from
**Southern
Water**

Our ref
PLAN-039305

Proposal: Medical centre with pharmacy retail unit & other ancillary uses together with access onto Barnham Road, associated car parking and other hard and soft landscaping works. This site is in CIL zone 2 (Zero Rated) as other development.

Site: BN/62/21/PL - The Croft Surgery, Barnham Road, Eastergate PO20 3RP.

C Drainage Layout Plan

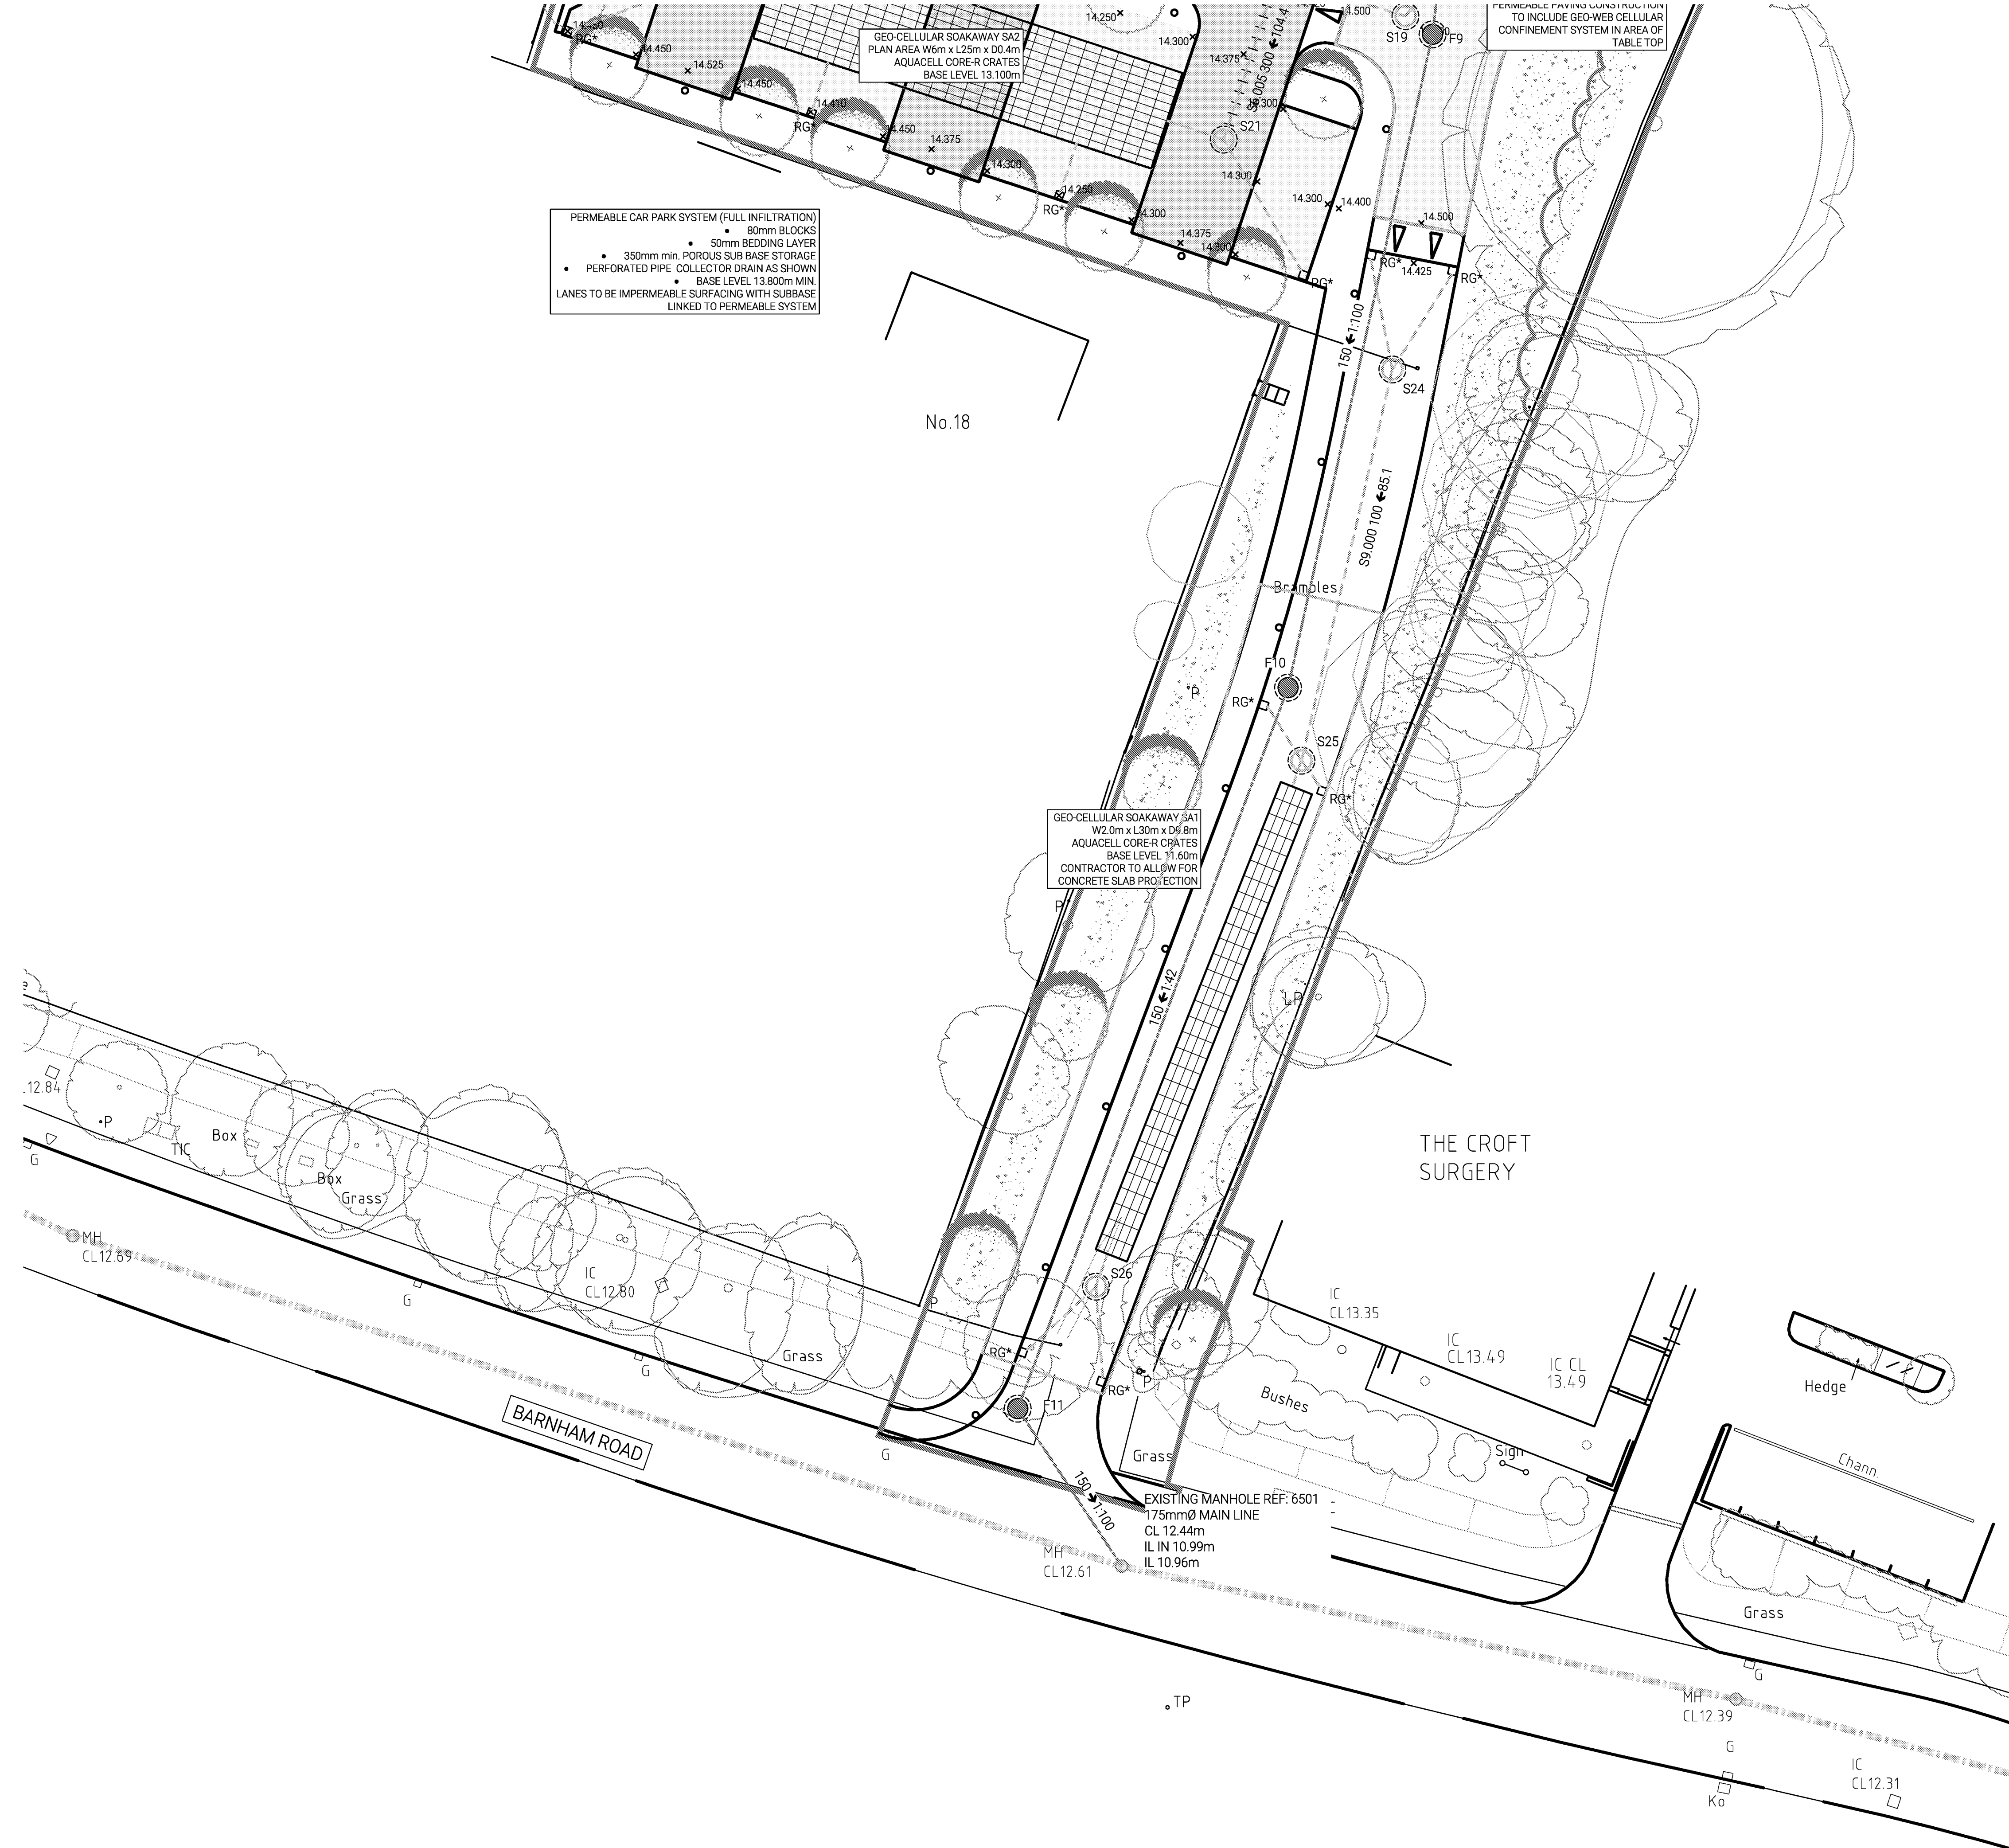
Please see the attached extract from Southern Water records showing the approximate position of our existing public foul sewer in the access of development site. The exact position of the public assets must be determined on site by the applicant in consultation with Southern Water before the layout of the proposed development is finalised.

- The 150 mm public foul sewer requires a clearance of 3 metres on either side of the gravity sewers to protect it from construction works and to allow for future access for maintenance.
- No development or tree planting should be carried out within 3 metres of the external edge of the public gravity sewer without consent from Southern Water.
- No soakaway, swales, ponds, watercourses or any other surface water retaining or conveying features should be located within 5 metres of a public sewer.
- All existing infrastructure should be protected during the course of construction works.

Furthermore, it is possible that a sewer now deemed to be public could be crossing the development site. Therefore, should any sewer be found during construction works, an investigation of the sewer will be required to ascertain its ownership before any further works commence on site.

The supporting documents make reference to drainage using Sustainable Drainage Systems (SuDS).

Where SuDS rely upon facilities which are not adoptable by sewerage undertakers the applicant will need to ensure that arrangements exist for the long-term maintenance of the SuDS facilities. It is critical that the effectiveness of these systems is maintained in perpetuity. Good management will avoid flooding from the proposed surface water system, which may result in the inundation of the foul sewerage system.

Thus, where a SuDS scheme is to be implemented, the drainage details submitted to the Local Planning Authority should:

- Specify the responsibilities of each party for the implementation of the SuDS scheme.
- Specify a timetable for implementation.
- Provide a management and maintenance plan for the lifetime of the development.

The Council's Building Control officers or technical staff should be asked to comment on the adequacy of soakaways to dispose of surface water from the proposed development.

Due to surface water inundation issues in the Lidsey Catchment the applicant is advised to adopt, where appropriate, the measures set out in the table "Practical measures to reduce the potential impacts of development". The developer should look to protect the public sewerage system from inundation and infiltration, which contribute to flooding in unfavourable conditions.

We request that should this application receive planning approval, the following condition is attached to the consent: "Construction of the development shall not commence until details of the proposed means of foul and surface water sewerage disposal have been submitted to, and approved in writing by, the Local Planning Authority in consultation with Southern Water.
